DECISION DELEGATED TO HEAD OF PLANNING

Application No: H02-0257-25 **Applicant:** Crowland Parish Council

Proposal: Proposed cemetery, amenity building, associated parking and landscaping

Location: Land Off James Road Crowland Spalding

Client Crowland Parish Council		
Project Cemetery Land off James Road, Crowland		
Drawing Proposed Site Plan		
Scale @ A2 1: 500		Date 14/02/25
Drawn By WW		Checked By LMS
Job Number 1144-9	Status FP	Purpose of Issue Planning
Drawing No. 1144-9_FP_SP02		Rev A

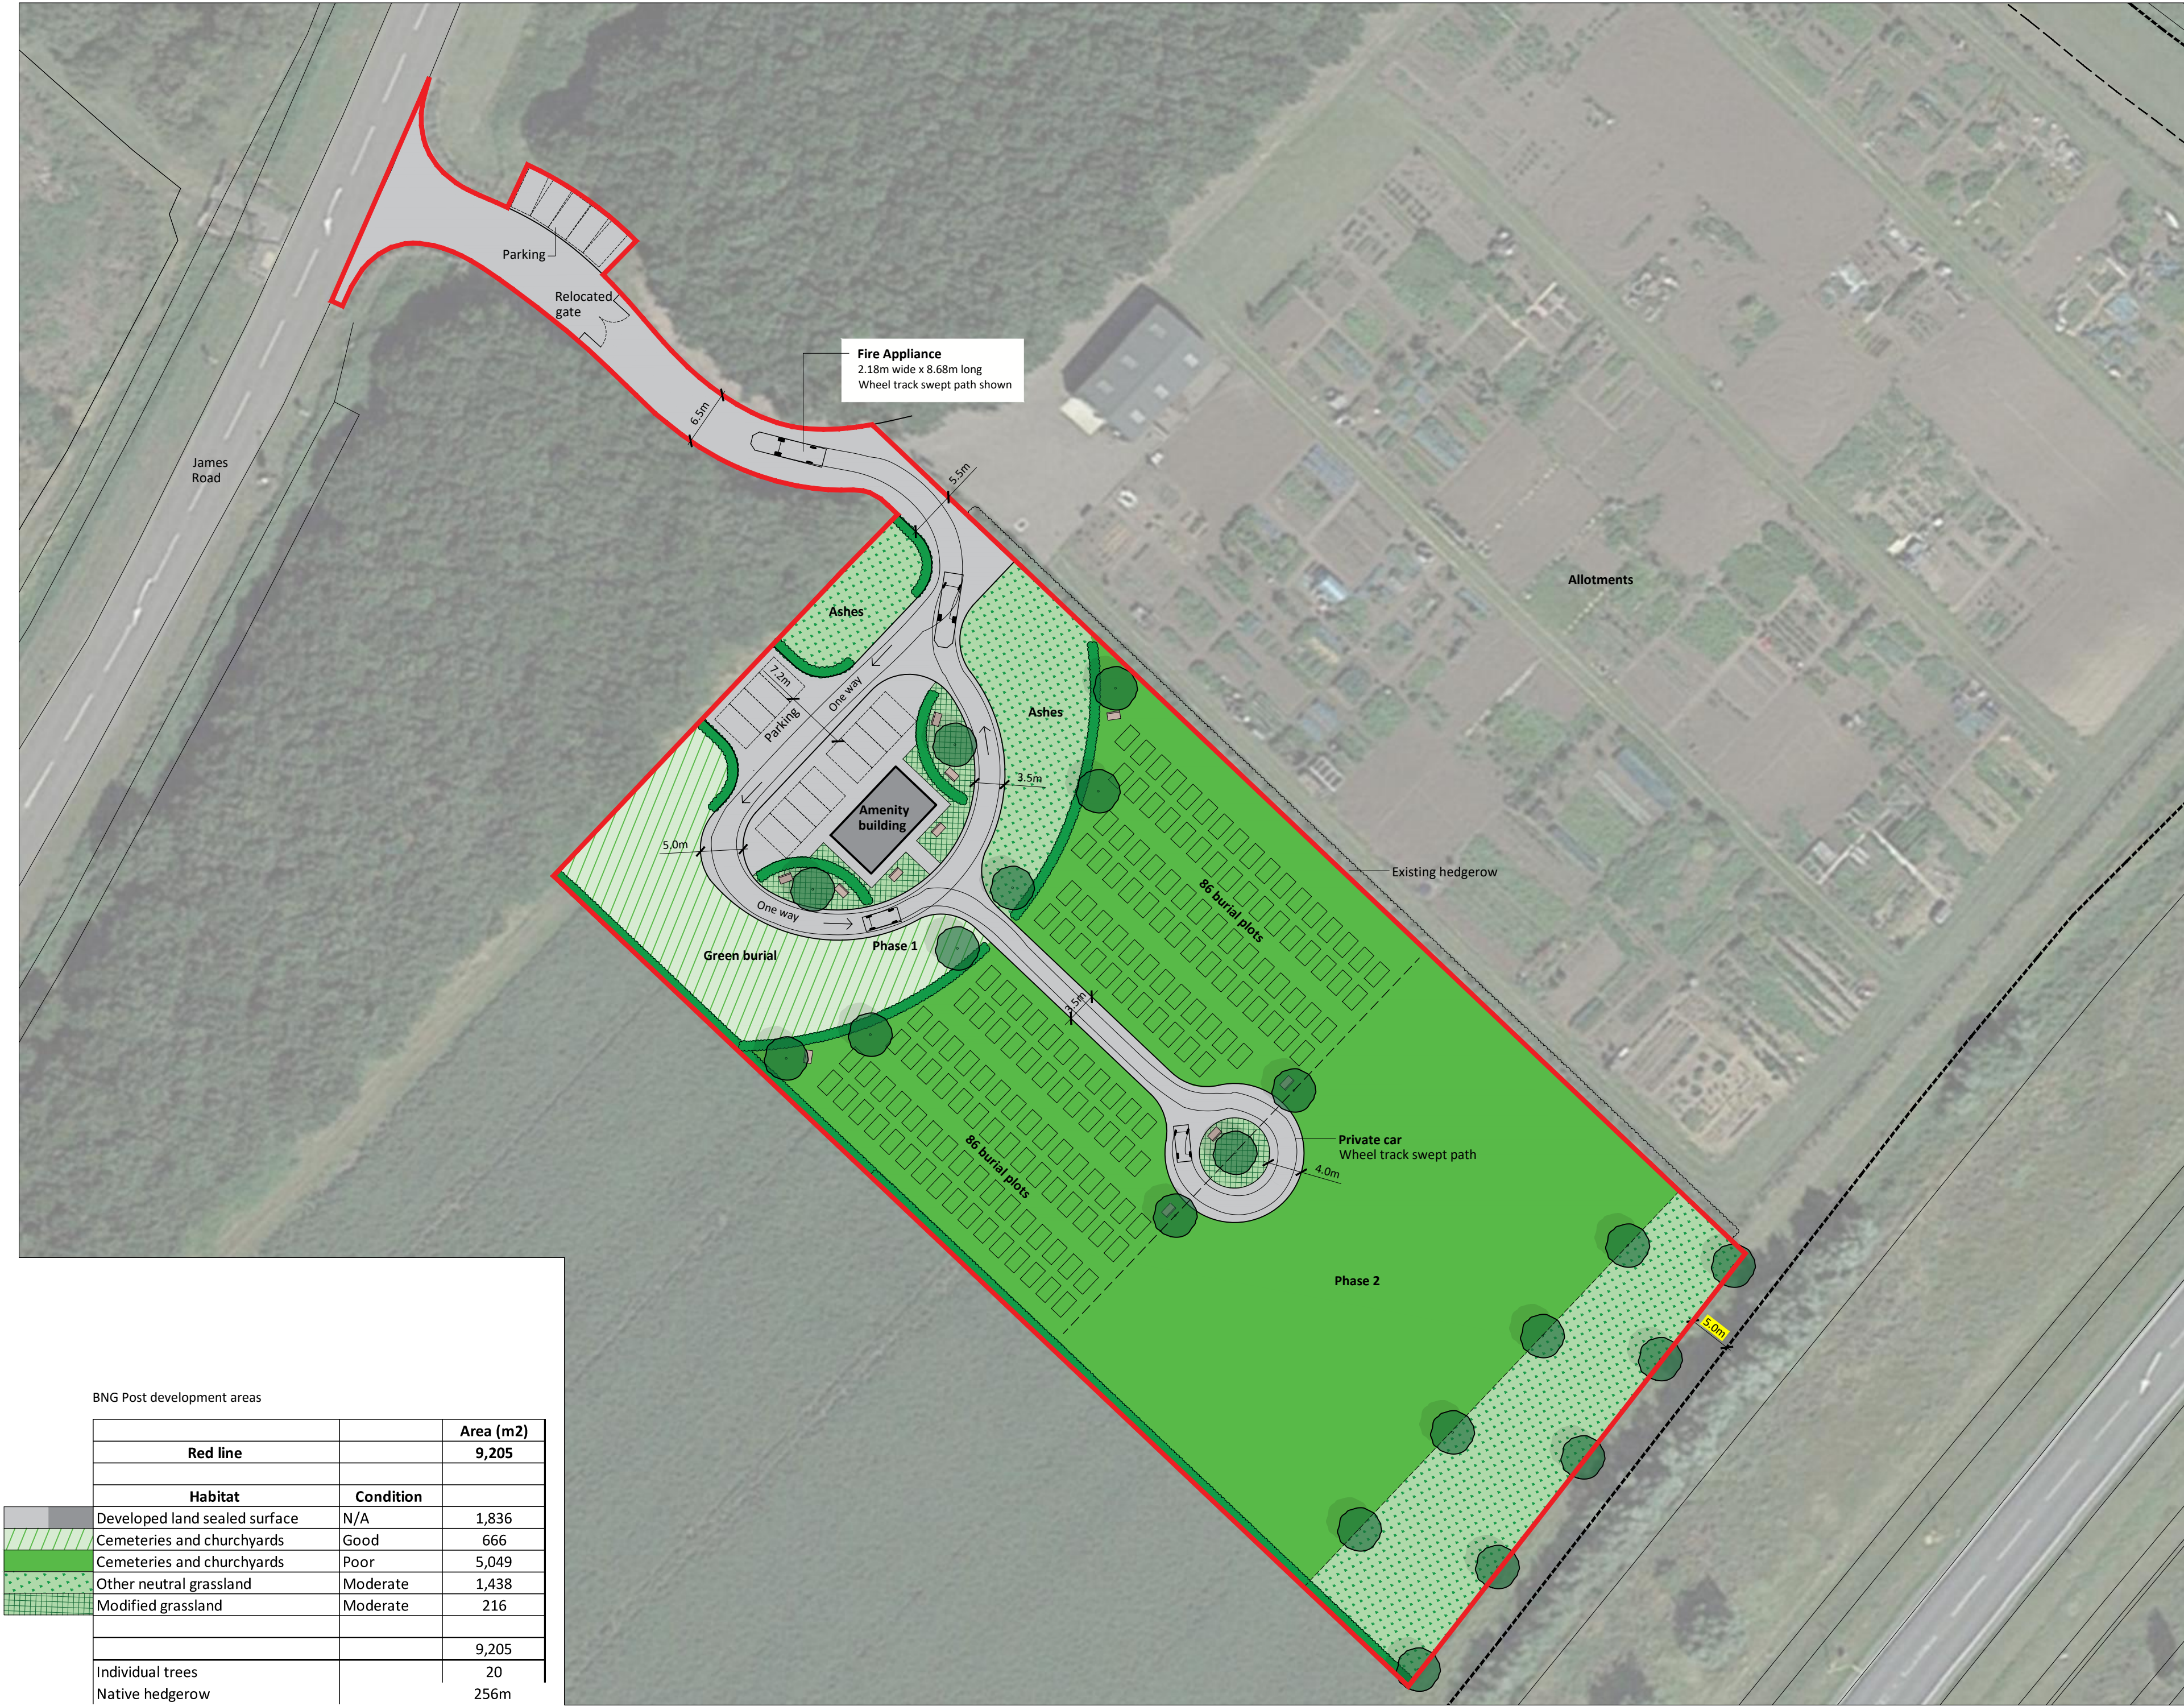
First Response (09 April 2025): A Simple Transport Statement is required. We need to be sure of the impact this could have on the highway network. Details required on vehicle and pedestrian movements associated with the proposal. It is noted that no pedestrian footway is proposed into the site - what is the justification for this? Road widths to be detailed on the block plan along with a swept path detail for the largest vehicle that will be accessing the site.

Second Response (12 May 2025): No objections. The proposal already has approval under 0771-18 and earlier applications this forms an amended layout submitted under a separate application so as not to complicate the existing Section 106 Agreement. I am happy with the parking justification; the access road and footway connections are already in place from the previous applications. The proposal will not have an adverse impact on the public highway.

Lincolnshire County Council's Highways and SUDS team requested further information including a transport statement to indicate anticipated vehicle and pedestrian movements associated with the proposed development. An amended site plan has also been provided to demonstrate that a fire engine can enter and exit the site. The highways team subsequently reviewed this information and confirmed that they have no objections to the proposed development. No conditions have been recommended. It is however considered appropriate to include a compliance condition requiring the parking spaces to be in place prior to the first use of the development in the interests of highway safety.
